KITITAS COUNTY
DEPARTMENT OF PUBLIC WORKS

MEMORANDUM

TO: Community Development Services
FROM: Christina Wollman, Planner II *CW*
DATE: May 14, 2009
SUBJECT: Markus-Repp Short Plat SP-09-00009

MARKUS-REPP SHORT PLAT
PART OF SECTIONS 29 & 30, T. 17 N., R. 19 E., W.M.

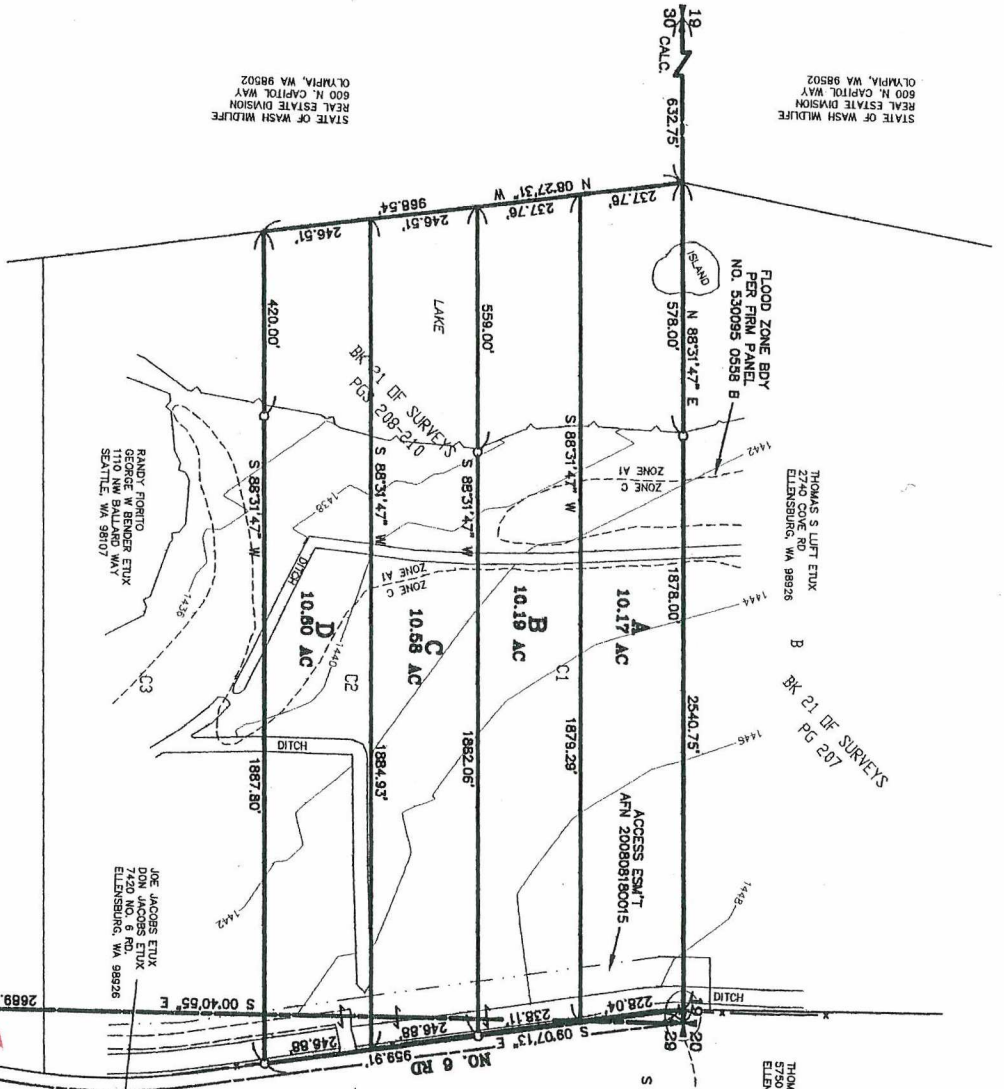
3. Private Road Improvements: Access from No. 6 Road shall be constructed to meet or exceed the requirements of a Low-Density Private Road. See Kittitas County Road Standards, 9/6/05 edition.

- a. Access easements shall be a minimum of 60' wide. The roadway shall have a minimum width of 20', with 1' shoulders, for a total width of 22'.
 - b. Minimum centerline radius will be 60'.

- c. The surface requirement is for a minimum gravel surface depth of 6".

- d. Maximum grade is 12%.
 - e. Stopping site distance, reference AASHTO.
 - f. Entering site distance, reference AASHTO.
 - g. Maintenance of driveway approaches shall be the responsibility of the owner whose property they serve. The County will not maintain accesses.

- j. All easements shall provide for AASHTO radius at the intersection of county road.
 - k. A paved apron shall be constructed at the intersection of the proposed private intersection and the county road right of way.

4. Cul-de-Sac: A cul-de-sac turn-around having an outside right-of-way or easement diameter of at least 110 feet shall be constructed at the closed end of all dead-end roads serving 3 or more lots. The driving surface shall be at least 96 feet in diameter. Cul-de-sacs must also conform to the requirements specified by the 2006 International Fire Code. Contact the Fire Marshal regarding any additional cul-de-sac requirements.
